10 September 2025

The Manager
Major Projects NSW
Department of Planning, Housing and Infrastructure

**Re: Submission of Objection to State Significant Development Application
SSD-82709458 at 19-25 Balfour Street, Lindfield, NSW 2070**

4 **OVERSHADOWING - 02PM JUNE 21 (PROPOSED)**
1 : 1000

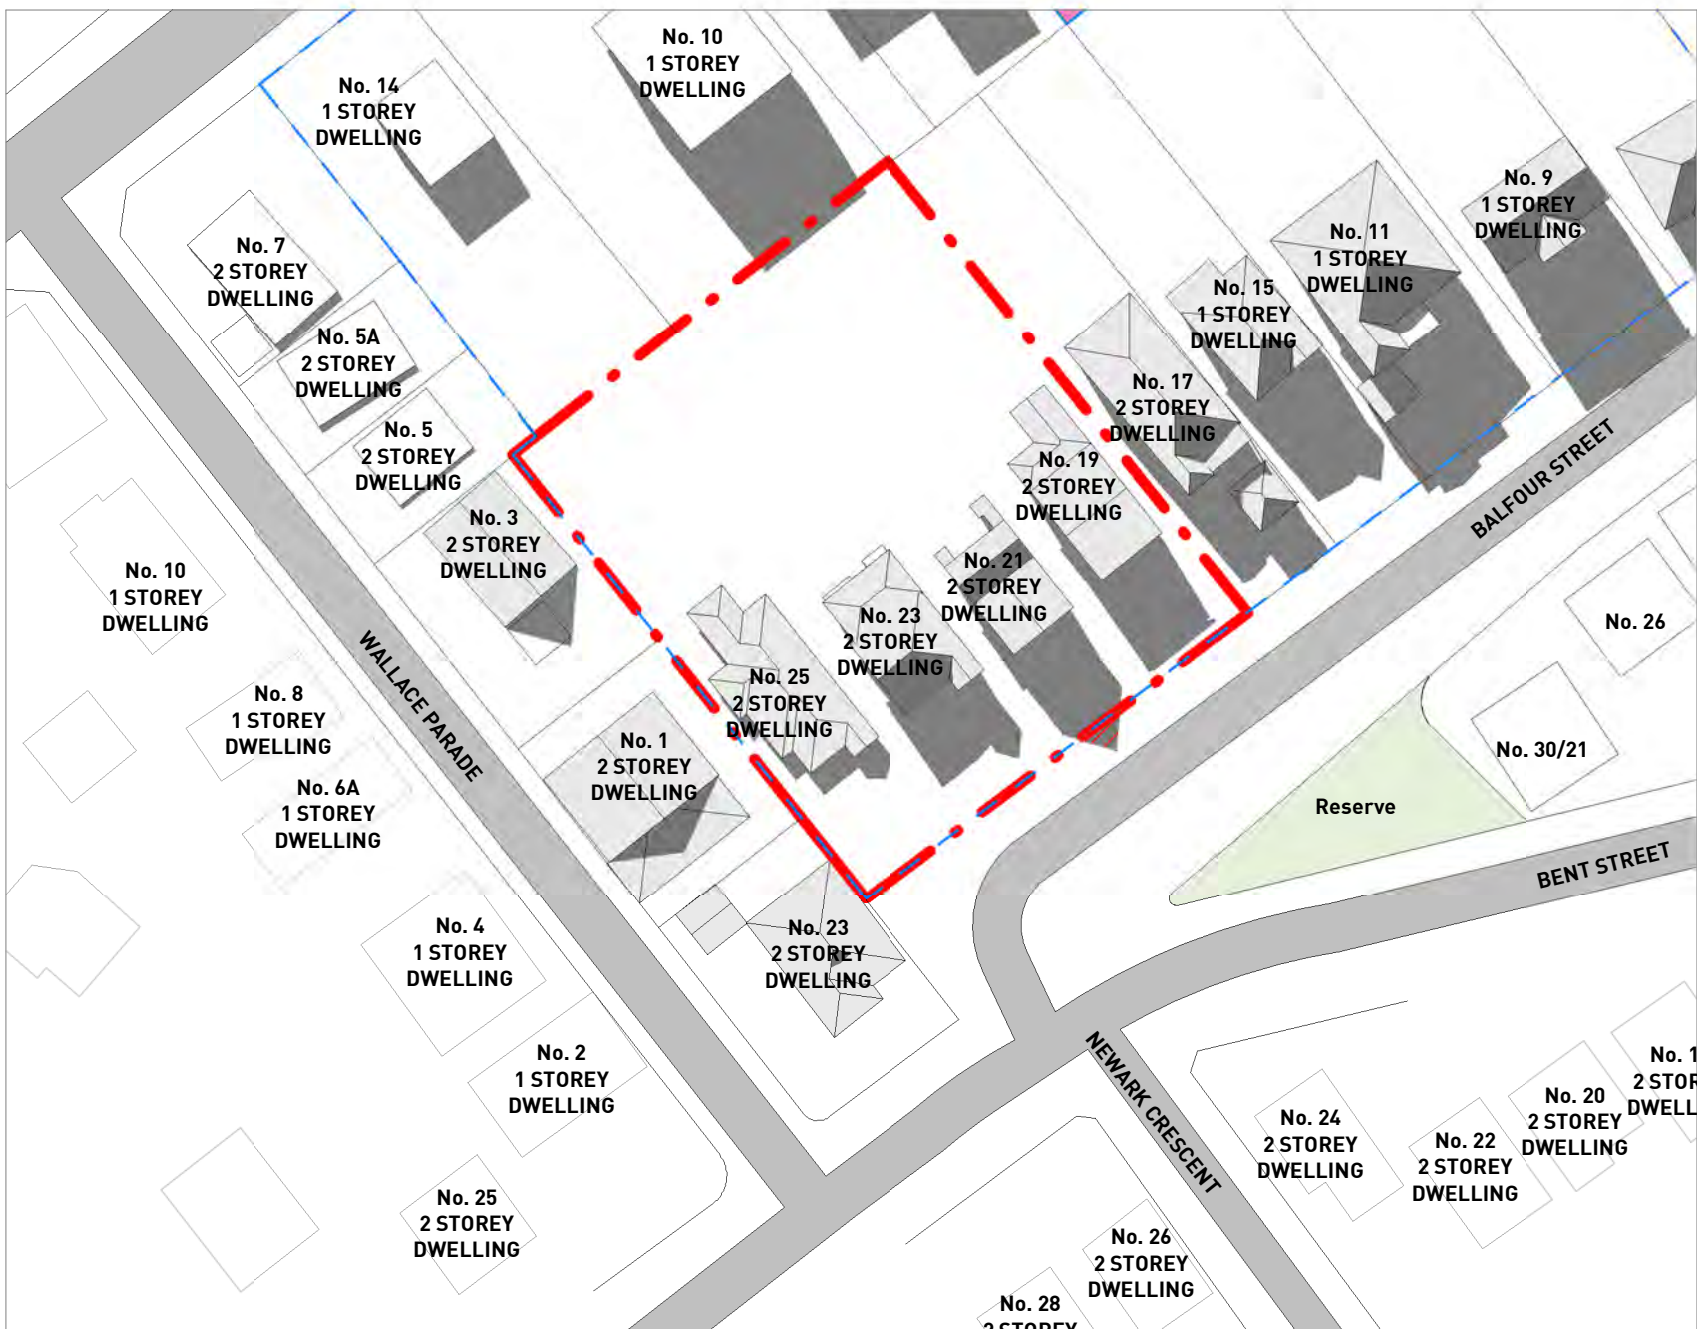
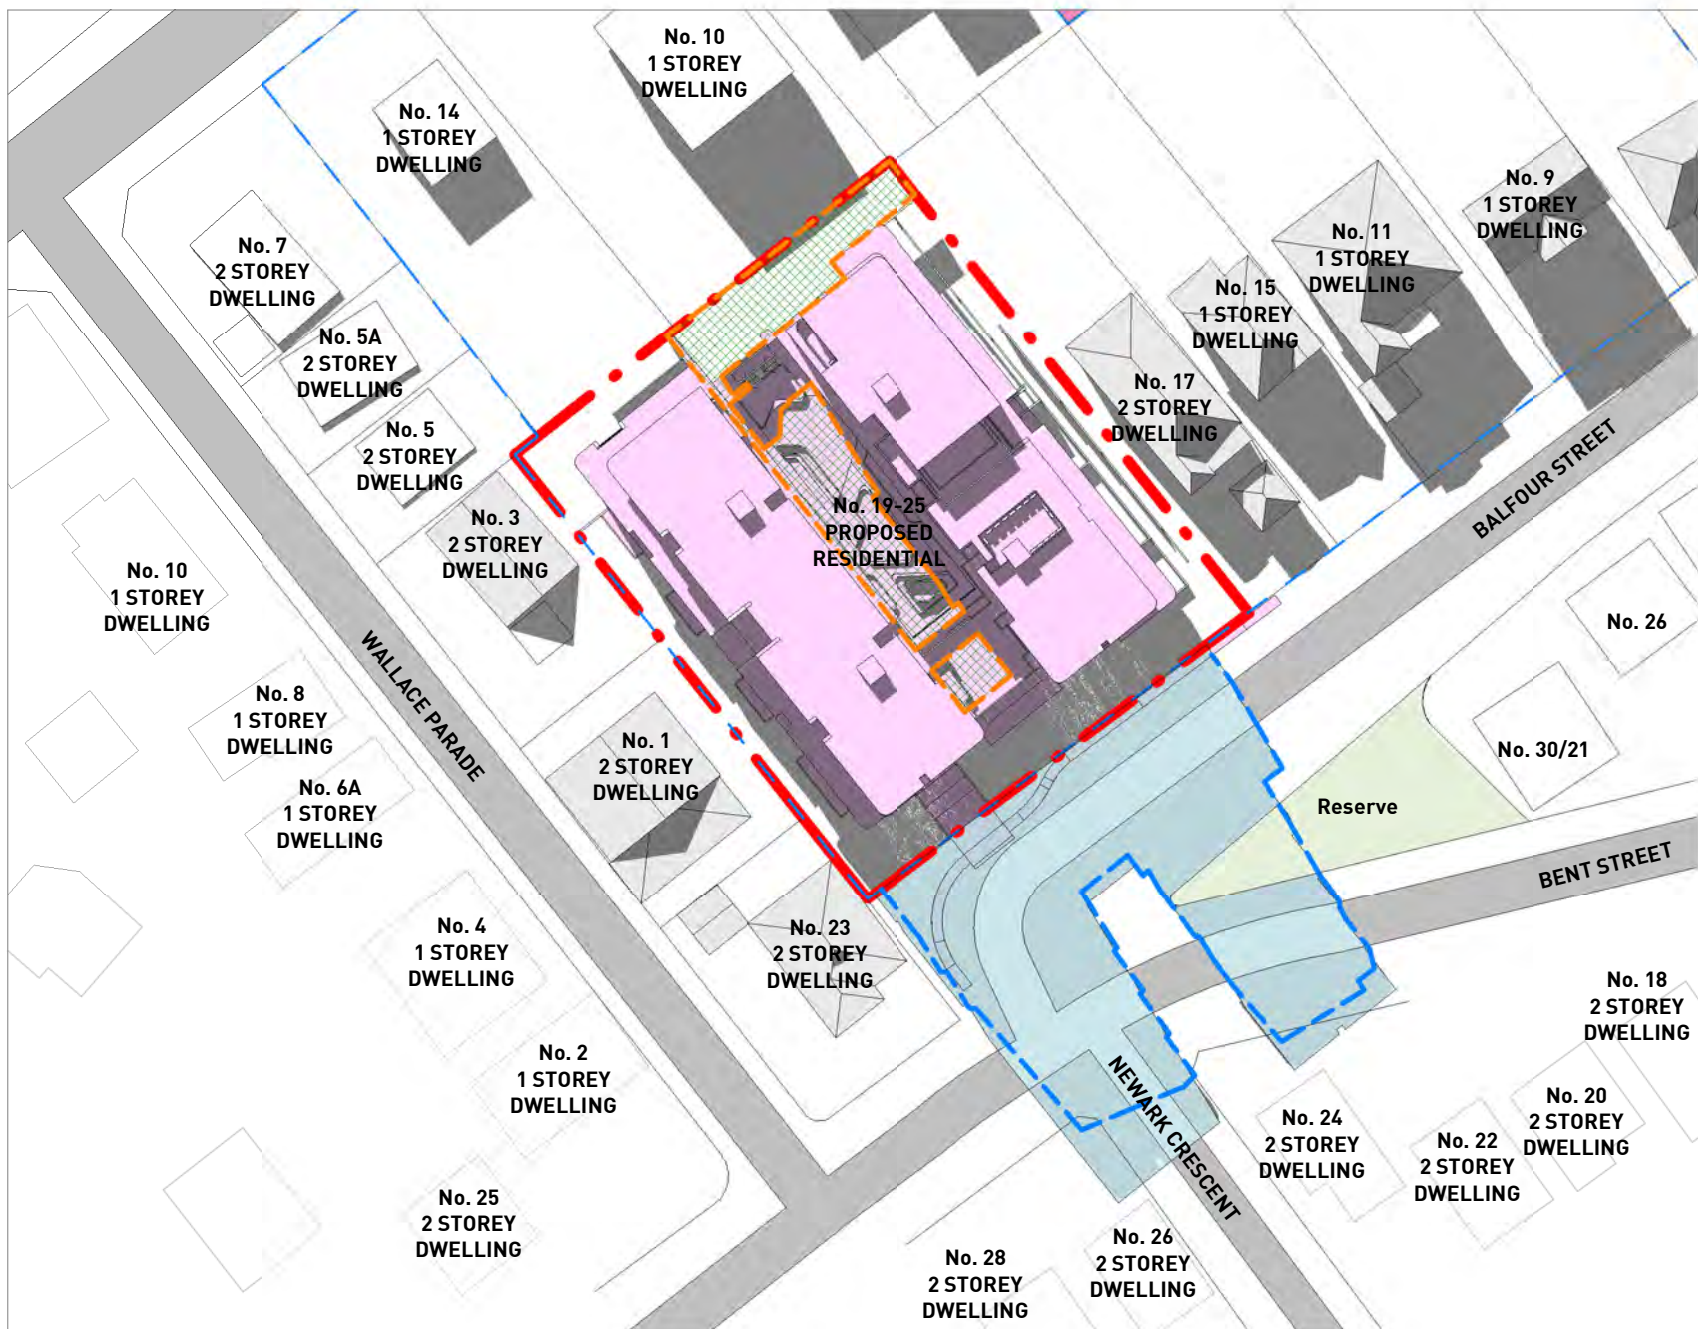
20-24 Bent Street during winter will be completely in shade from 2:30pm onwards during winter solstice, meaning any solar access or solar panels installed there will be ineffective. Thus, the height of this development must be reduced.
